Development Facilitation Team (DFT) – Review Comments

Project No: PR-2025-011406 Date: 6/11/2025 Agenda Item: #8 Zone Atlas Page: J-13

Request: lot consolidation of Lots 23 & 24, Block 41, Perea Addition. A DHO Waiver on Alley ROW Width to be submitted concurrent with minor plat.

Location: 701 14th St NW between Marble & Granite NW

PROJECT NO. 24076 SHEET 1 OF 2

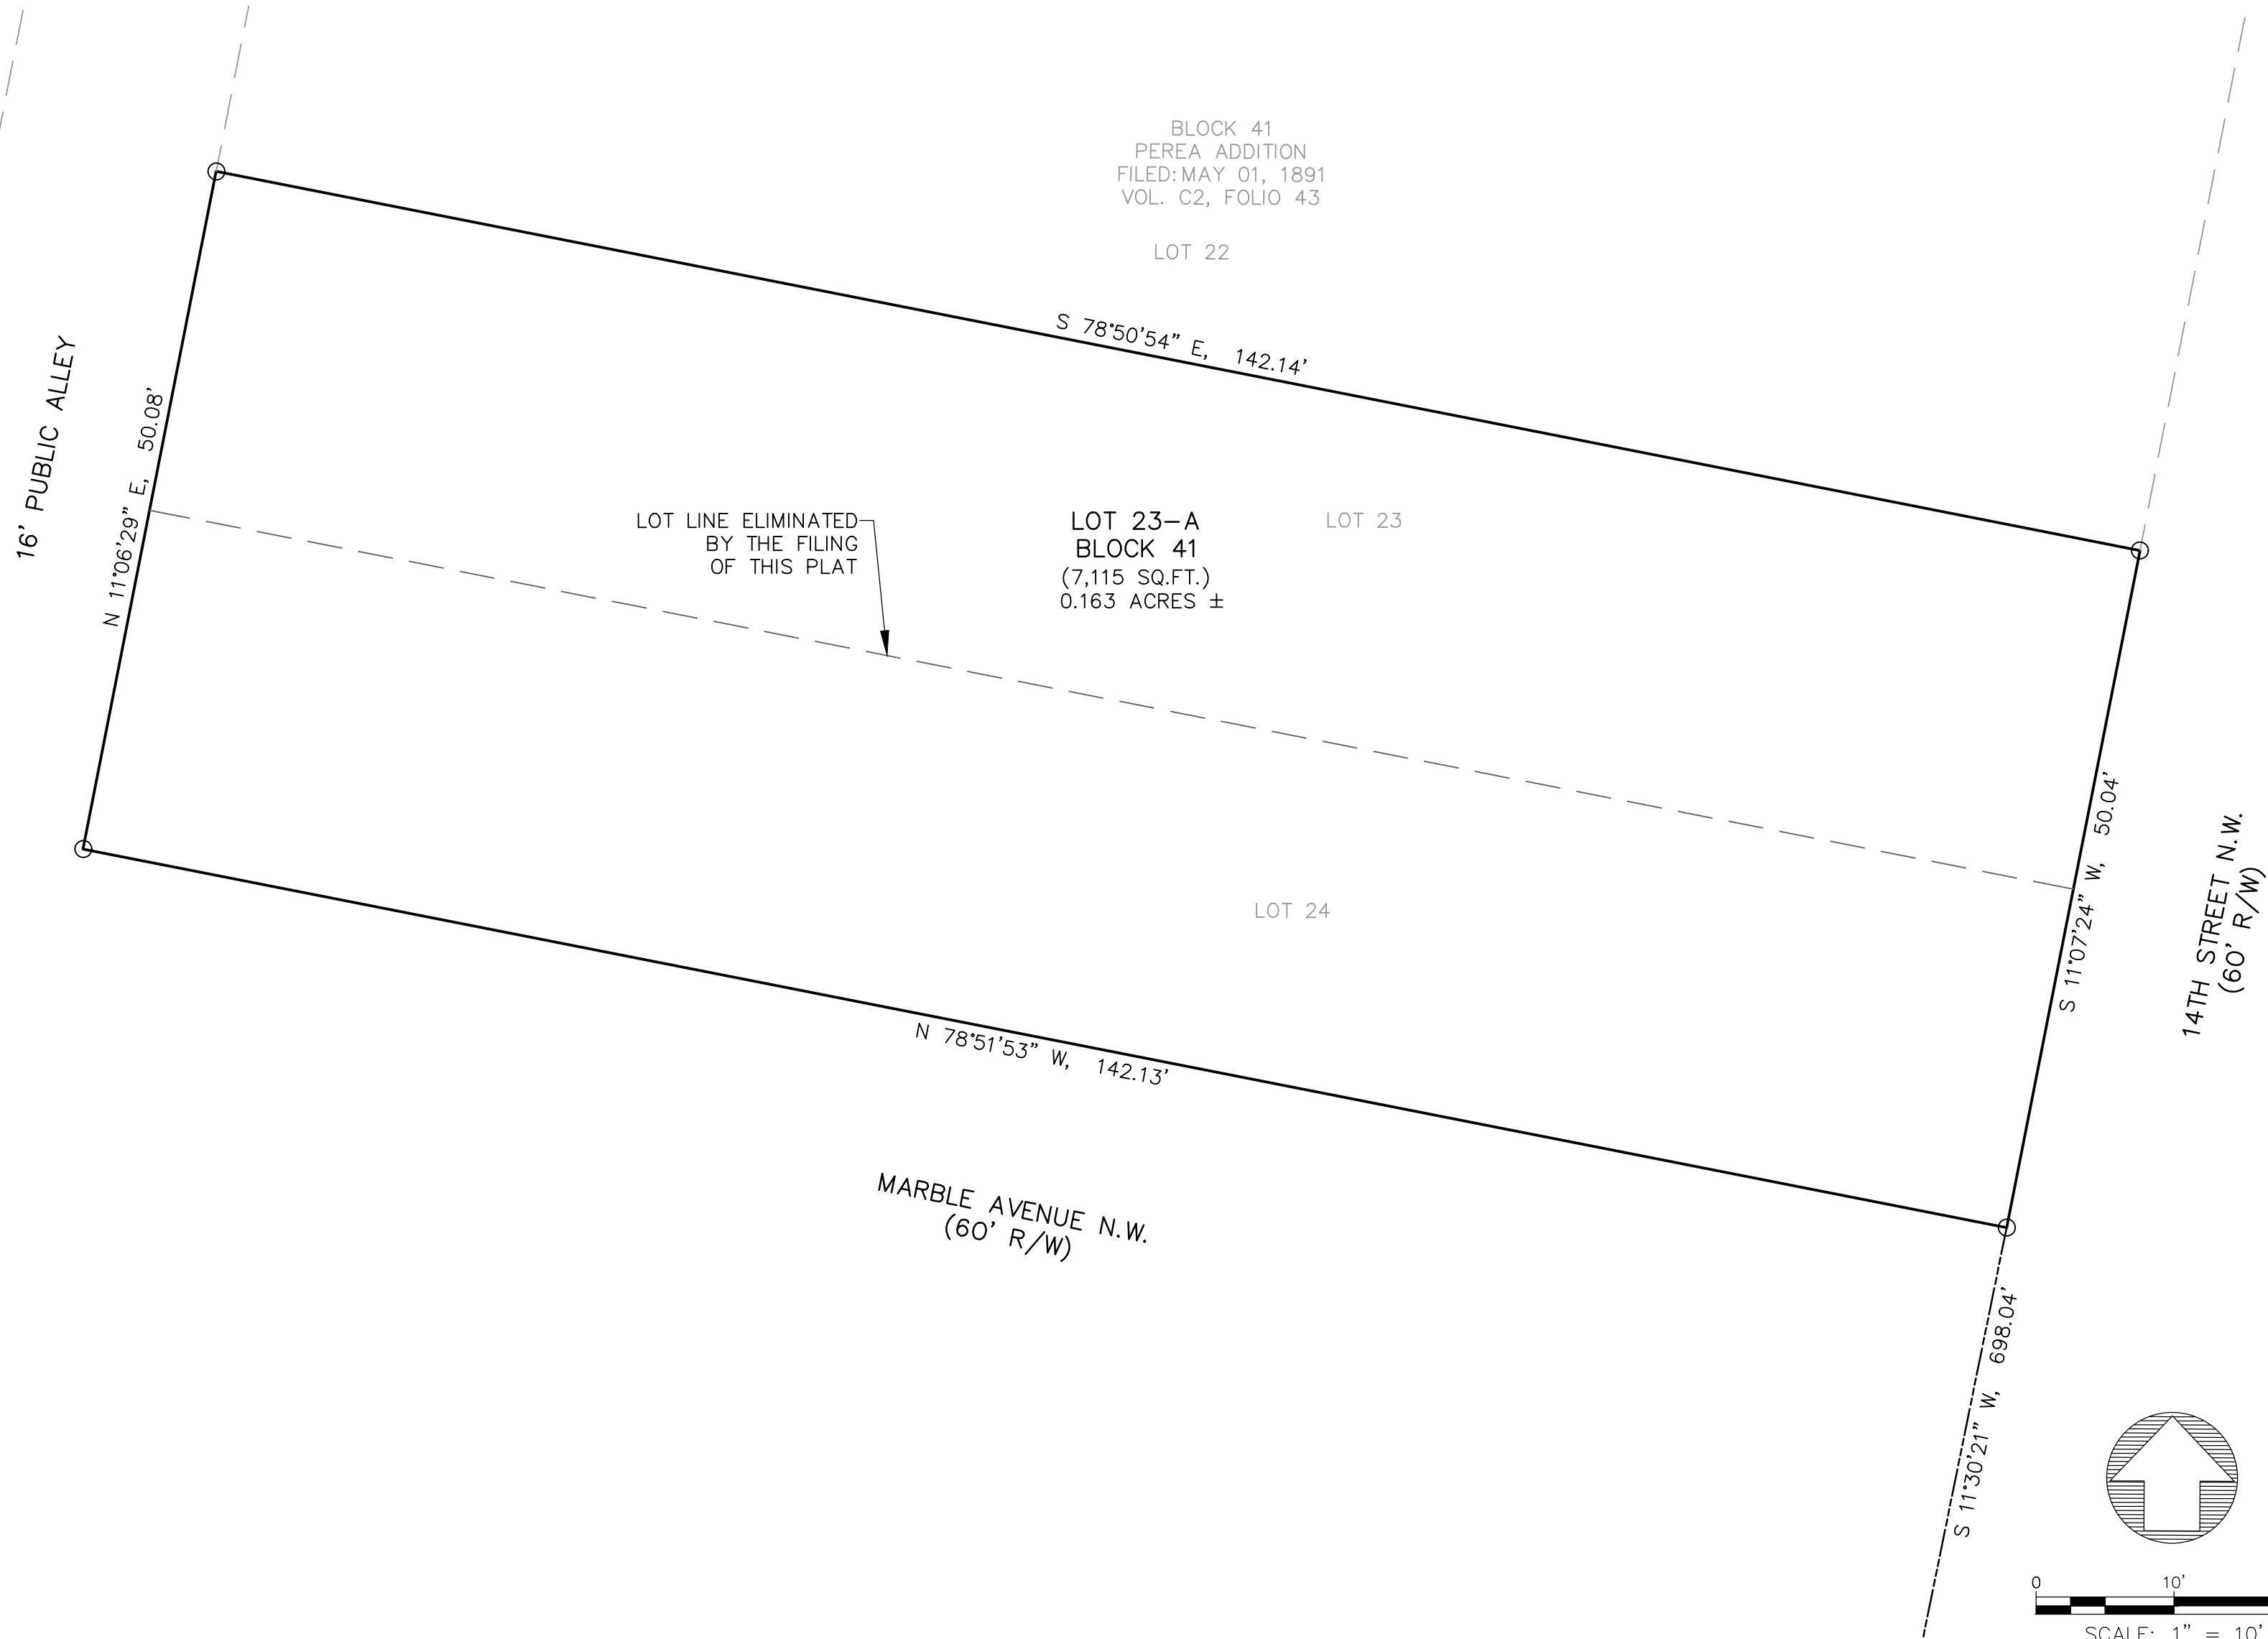
➤ DFT staff (transportation) did request a note on the plat which states the following:

‘Please note, parking with any part of the vehicle overlapping the public sidewalk is not allowed and the owner may be cited’.

- ✓ The Plat contains the requested note as #5 on sheet 1 of 2.
 - ✓ The DHOWVR-2025-00005 has been noted with date of approval by the DHO.
 - ✓ The Applicant properly notified the Neighborhood Associations sent by ONC per Table 6-1-1 of the IDO.
